Location of Construction: 531 Congress St	Owner Name: Hega Realty Trust	Owner Address: 218 East Rd	Phone:
Business Name:	Contractor Name: Keeley Construction	Contractor Address: P.O. Box 1174 Portland	Phone 2077738499
Lessee/Buyer's Name	Phone:	Permit Type: Change of Use - Dwellings	Zone:

Dept: Zoning **Status:** Approved with Conditions **Reviewer:** Marge Schmuckal **Approval Date:** 12/22/2005

Dept: Building **Status:** Approved with Conditions **Reviewer:** Mike Nugent **Approval Date:** 01/13/2006

WALL TYPES

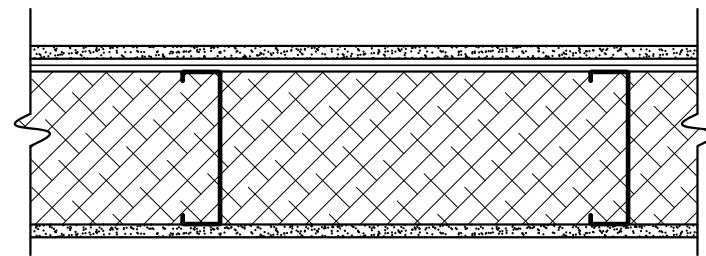
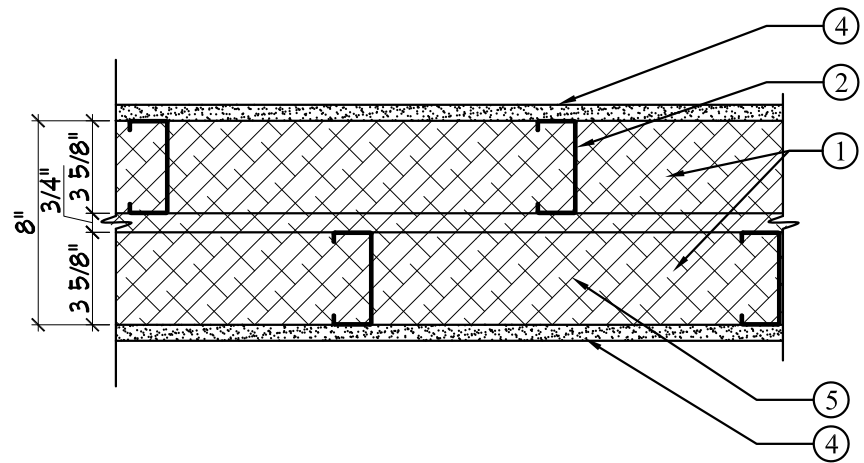
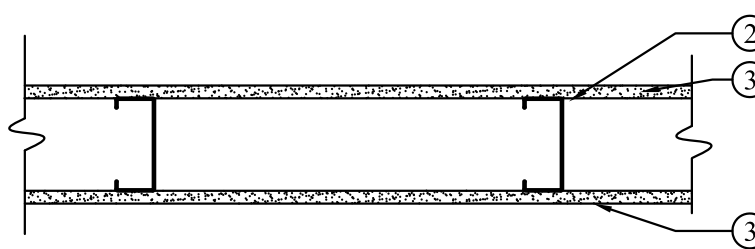
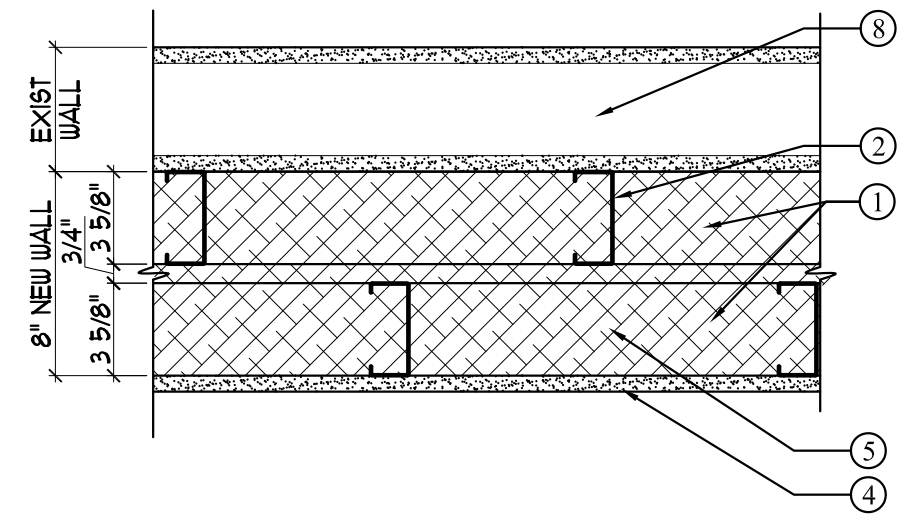
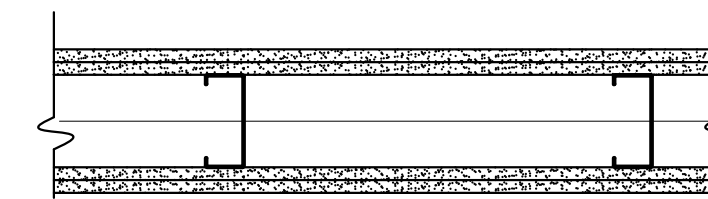
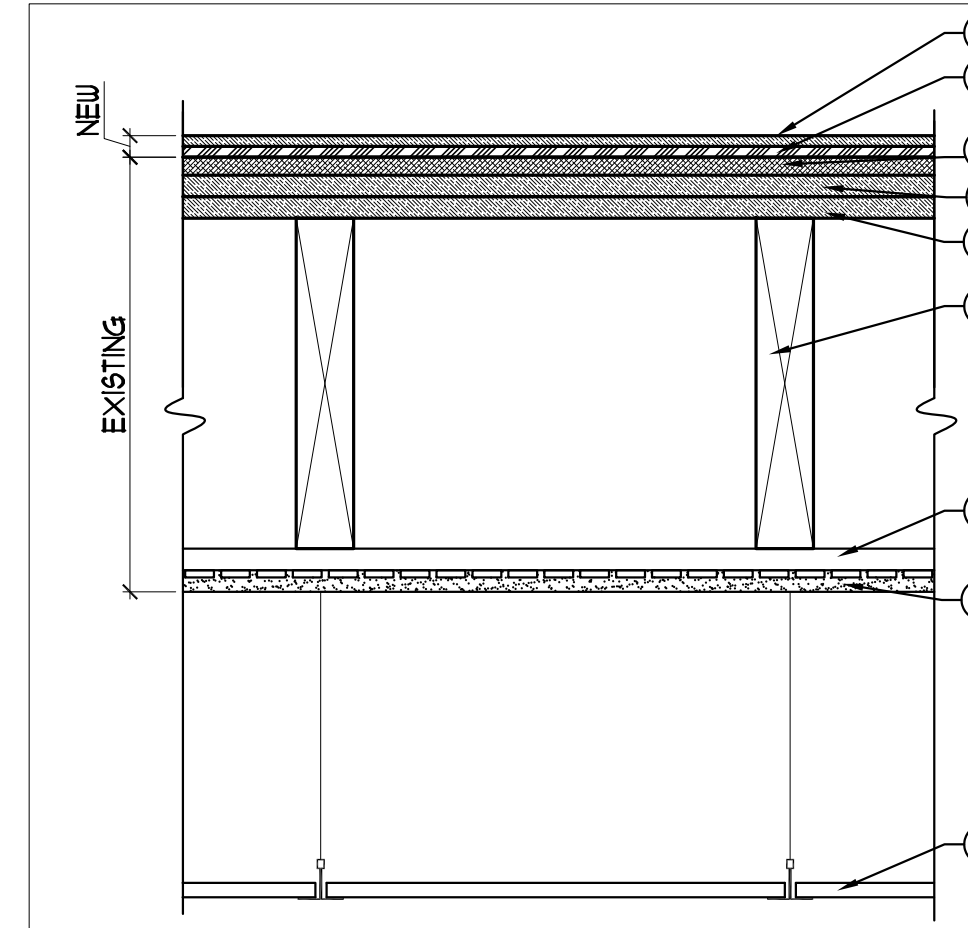
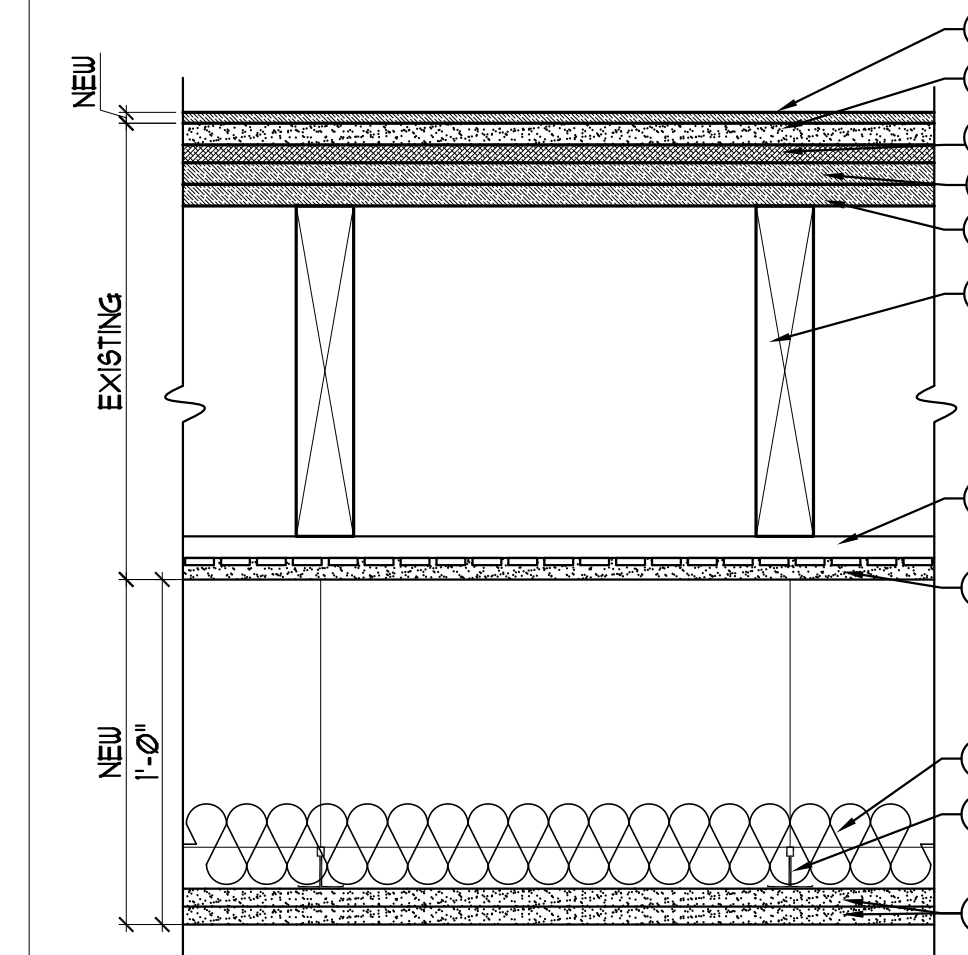
what is the STC of the wall assemblies

Floor ceiling assembly and over all penetration protection plan?? Also what are we doing between the mixed uses (4th and 5th floors?)
